Subject: EIS - First Building Bradfield City Centre (SSD-25452459) (Liverpool City)

Attachment A – EES Waterway health comments for the First Building Bradfield City Centre (SSD-25452459)

Comments are specific to Section 3 – Stormwater Management of the Bradfield Civil Design Report and the relevant Civil Engineering Plans provided at Appendix D of the EIS.

GENERAL ARRANGEMENT  
POST DEVELOPMENT CATCHMENT PLAN

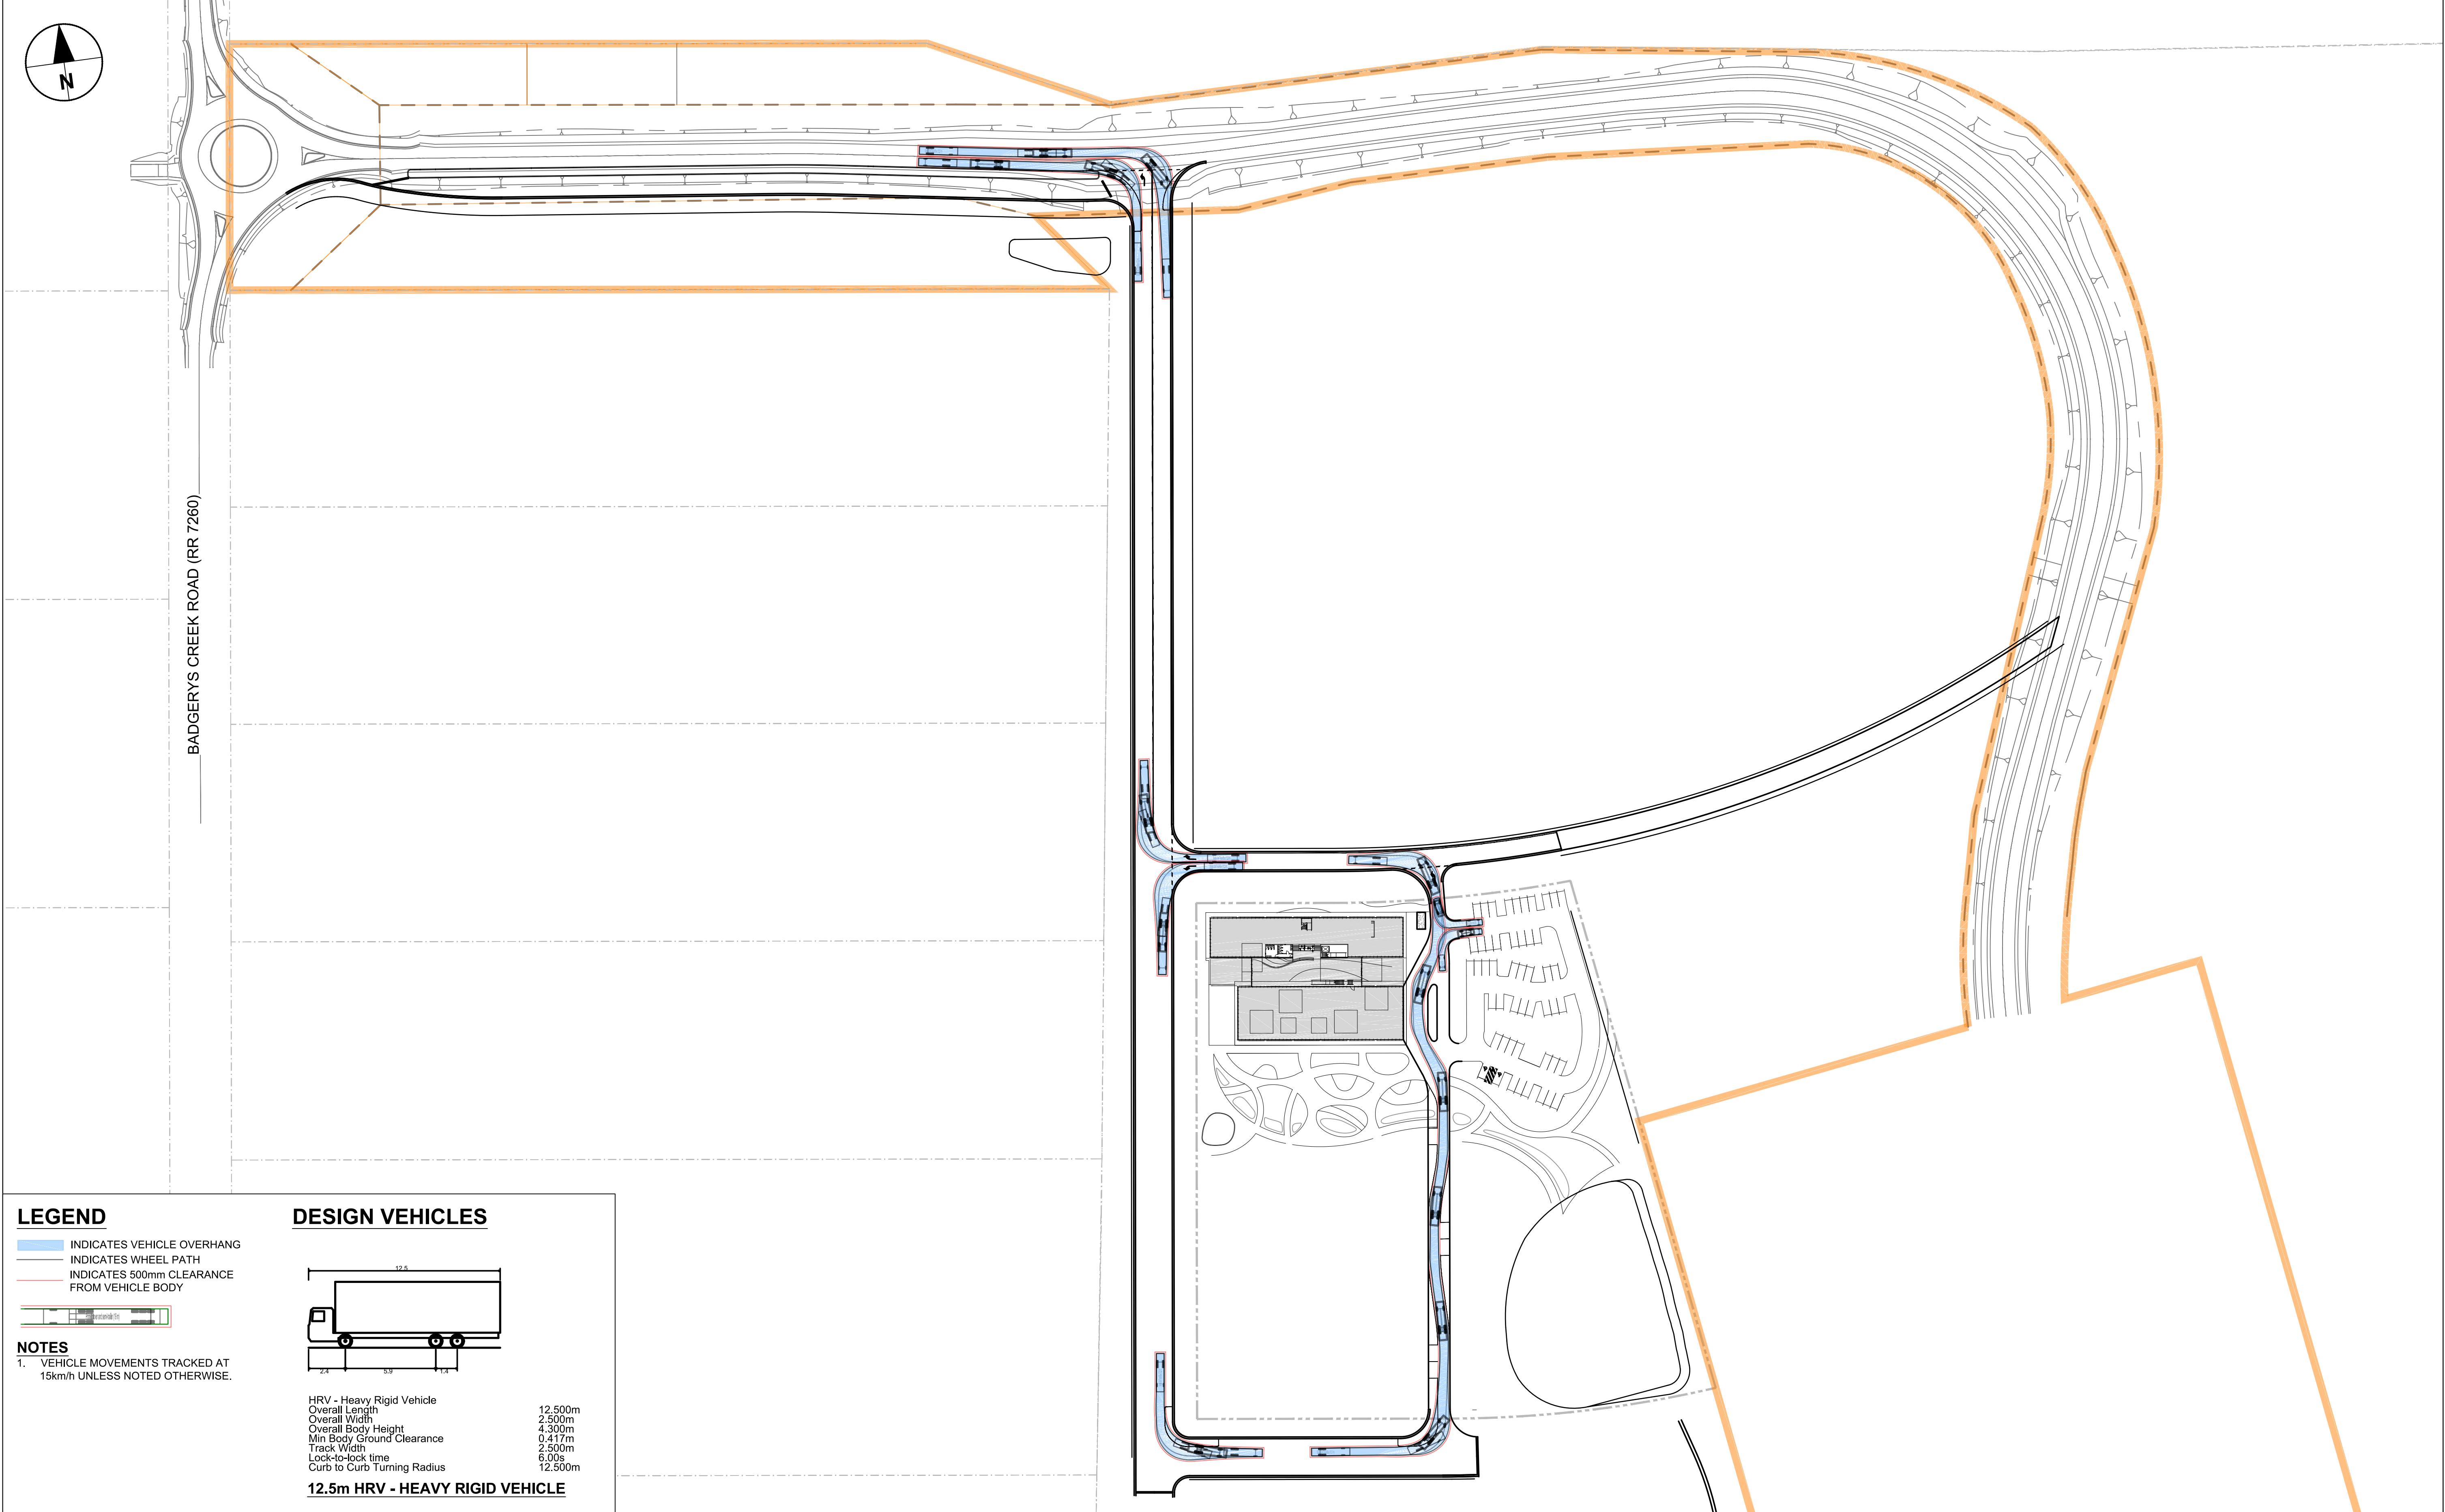
- Some detailed catchments plans are provided in the Civil Engineering Plans, but the Civil Design Report does not provide catchments plans for the areas draining to the stormwater management systems. Catchment details such as areas, imperviousness and land types (road, roof, ground level, car parking) for each catchment should be included.

- No treatment is provided for the road catchment draining north. The applicant is to clarify how the stormwater targets for these northern catchments are to be achieved in the interim onsite detention basin.
